Walker Reserve

Preliminary

The Northeast Quarter of the Southwest Quarter of Section 11,
Township 11 South, Range 66 West of the 6th P.M.,
County of El Paso, State of Colorado.

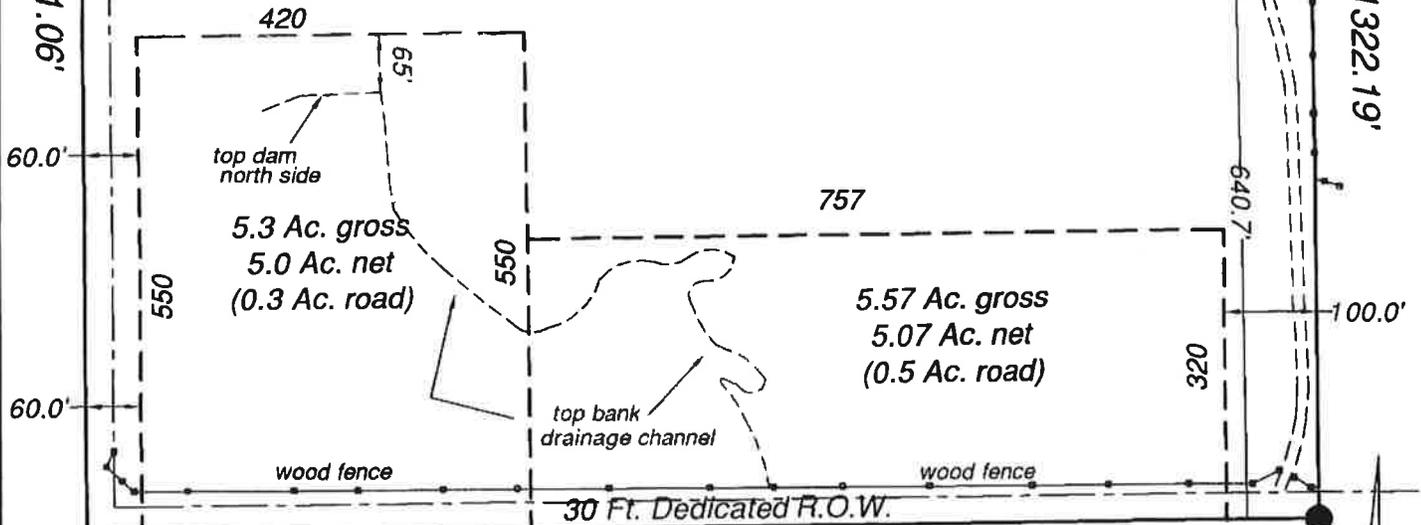
This drawing should be a final plat document, not a preliminary plan. The plat should not include any structures. It should contain all typical plat notes, signature blocks, certifications, etc. With the minor subdivision you complete both actions in one, but the plat document is that of the final plat.

This drainage way also extends through lot 3. Provide drainage easement with bearing and distance that encompasses the entire drainage way through all lots.

likely wetlands and should be no build area. Additional comments to be provided upon receipt of the soils and OWTS report. Add net acreage if no build.

should be graphically depicted as well.

Add PCD File #

Easements:
Unless otherwise indicated, all side, front, and rear lot lines are hereby platted on either side with a 10 foot (use 5 feet for lots smaller than 2.5 acres) public utility and drainage easement unless otherwise indicated. All exterior subdivision boundaries are hereby platted with a 20 foot (use 7 feet for lots smaller than 2.5 acres) public utility and drainage easement. The sole responsibility for maintenance of these easements is hereby vested with the individual property owners.

Private Roads:
The private roads as shown on this plat will not be maintained by El Paso County until and unless the streets are constructed in conformance with El Paso County standards in effect at the date of the request for dedication and maintenance.
